BCA Assessment Report Report 2021/0268 R1.1

Prepared for Pymble Ladies' College
August 2021

An assessment of the design of the proposed Pymble Ladies' College Grey House Precinct located at the Pymble campus, Sydney NSW has been undertaken against the Deemed-to-Satisfy (DTS) provisions of the relevant sections of the Building Code of Australia and the applicable Building Regulations.

LEVEL 00 PLAN

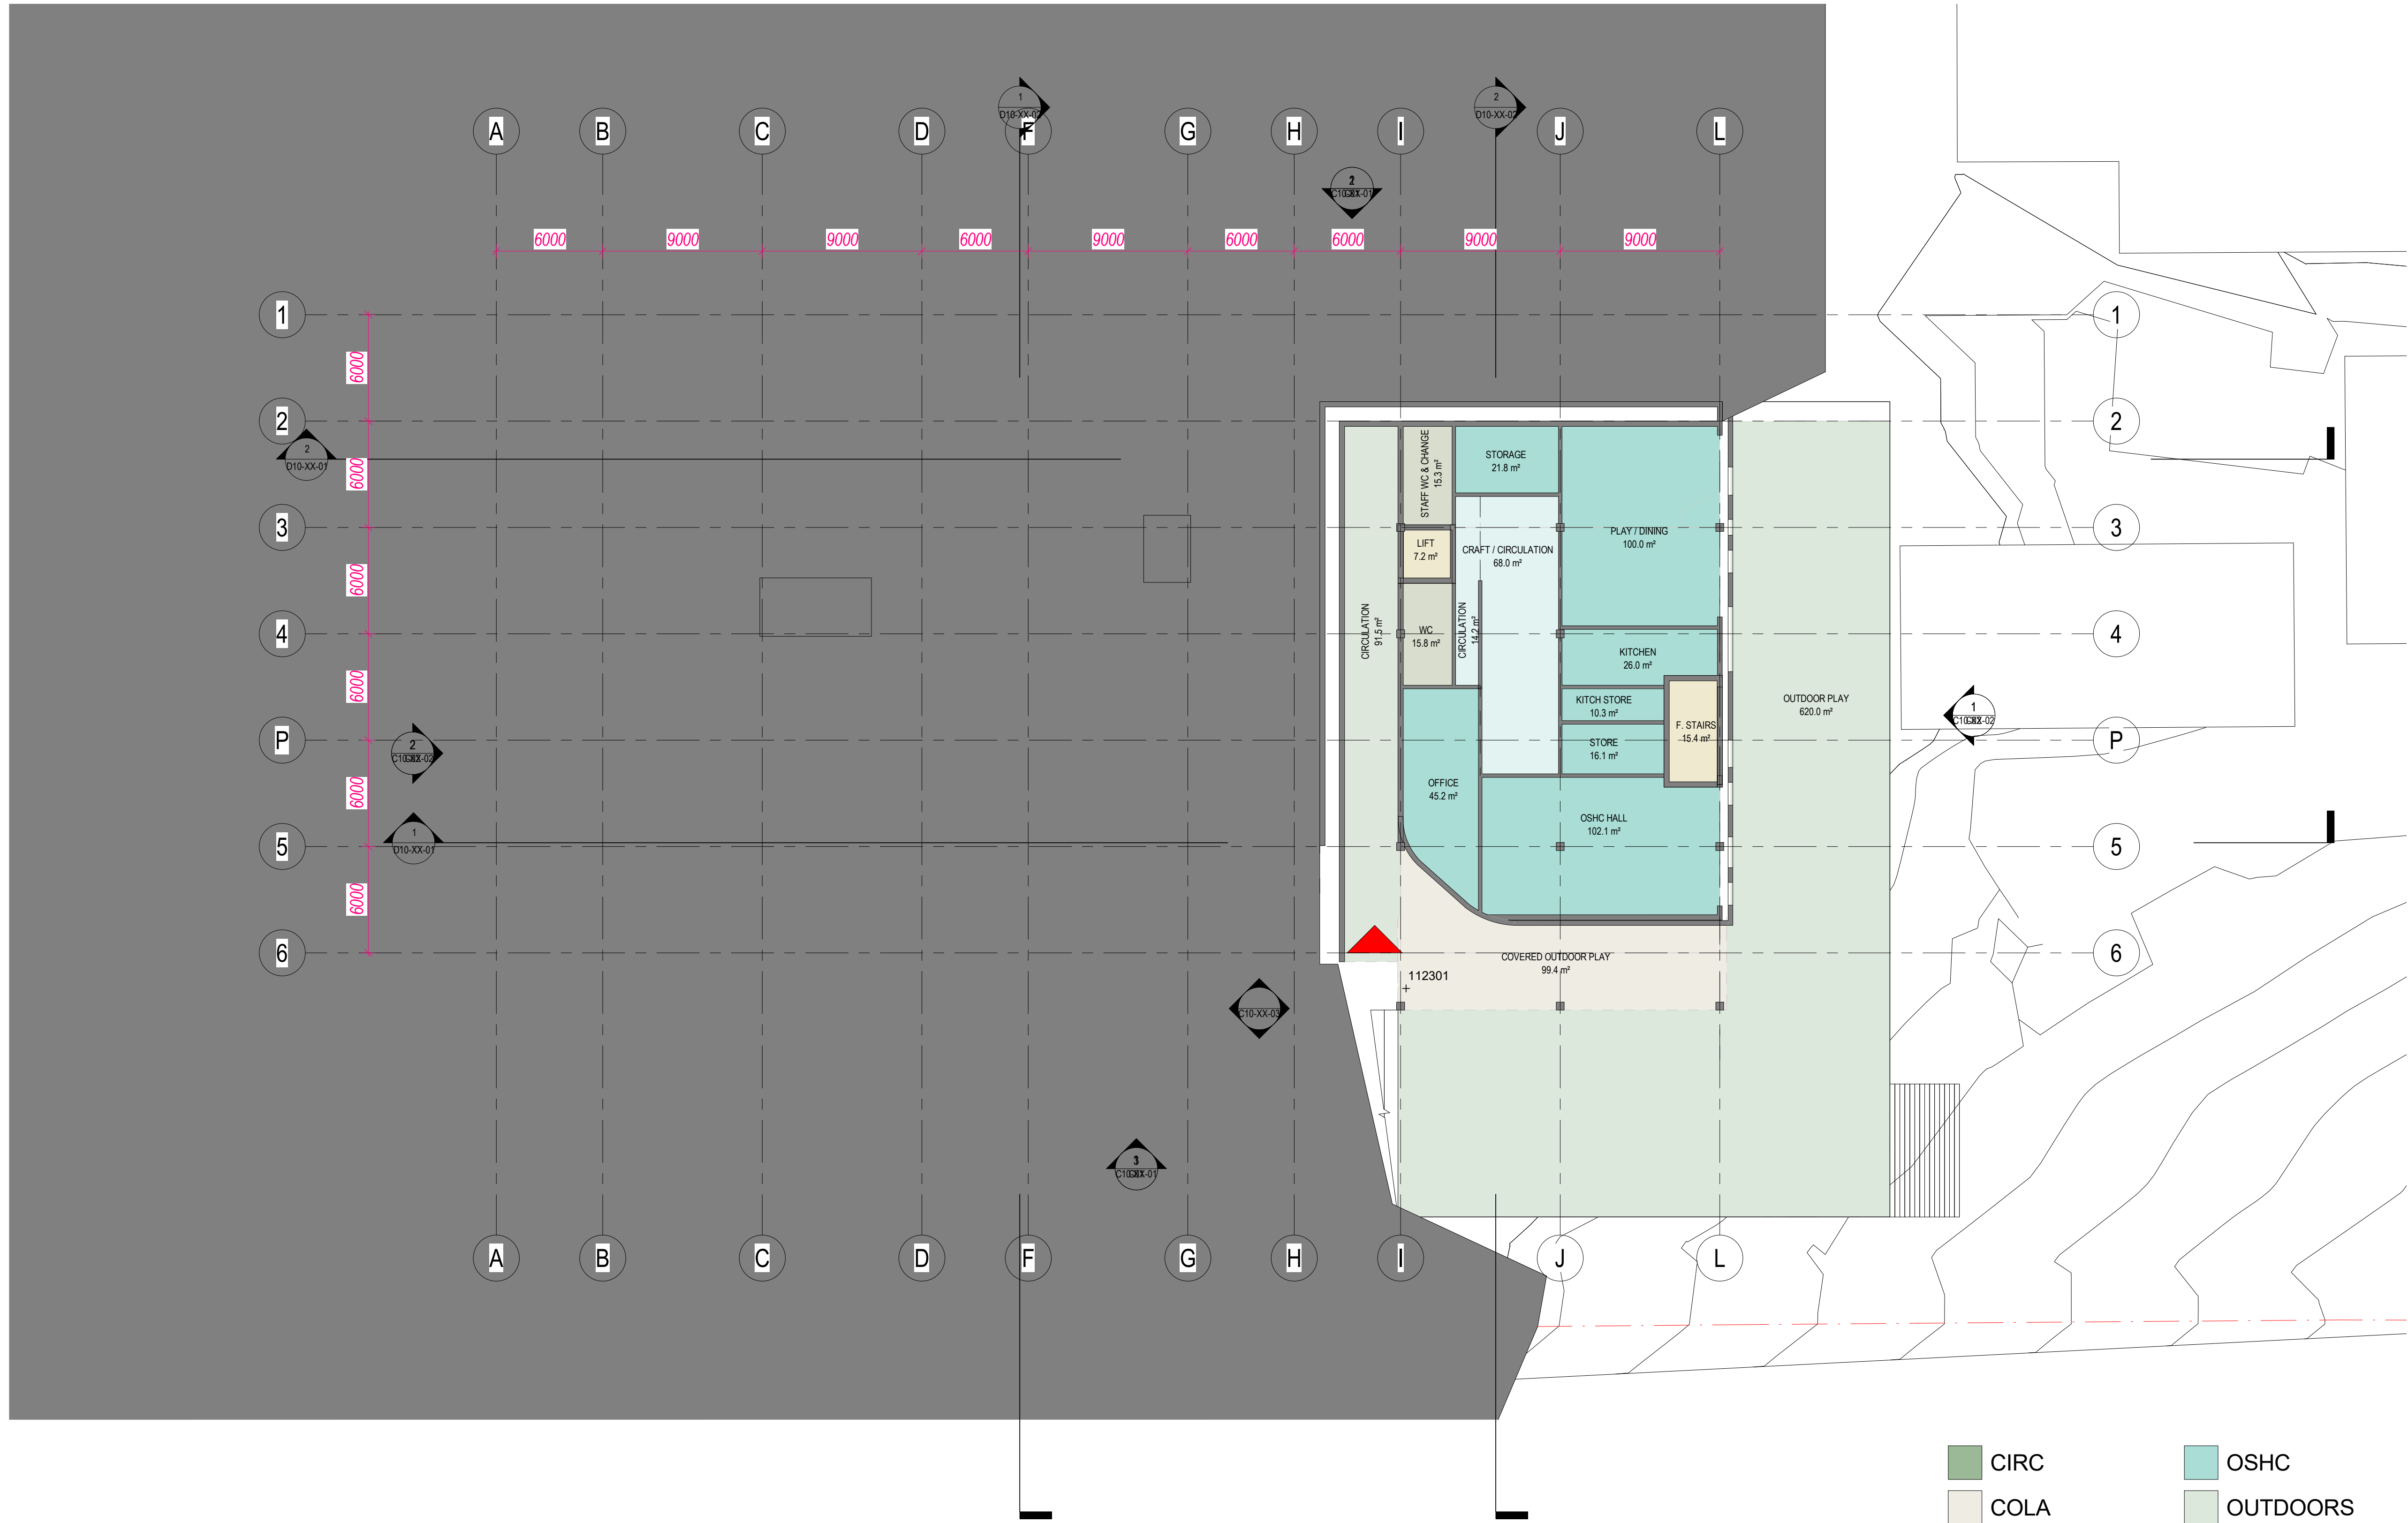
1. The subject openings identified in OSHC on Level 00 are within the 6m & exposed to the western external wall of the adjoining building to the east (Junior School)

Item	Non-Compliance	DTS Clause	Description	Performance Requirement
1.	The subject openings identified in OSHC on Level 00 are within the 6m & exposed to the	C3.2	The western external wall of the adjoining building to the east (Junior School) is within 6m of the proposed OSHC on Level 00 and the following are not protected: a. Window openings east elevation kitchen exposed to the	CP2 & CP8

Item	Non-Compliance	DTS Clause	Description	Performance Requirement
	western external wall of the adjoining building to the east (Junior School)		<p>adjoining building.</p> <p>b. Double doors opening east elevation exposed to the adjoining building.</p> <p>The openings will need to be protected in accordance with C3.4 or the design modified. Note that most methods of protecting windows require either fixed or automatic closing windows.</p> <p>OR</p> <p>It is recommended to discuss with the fire engineer if they are able to support a performance solution for the subject openings being within the 3m separation</p>
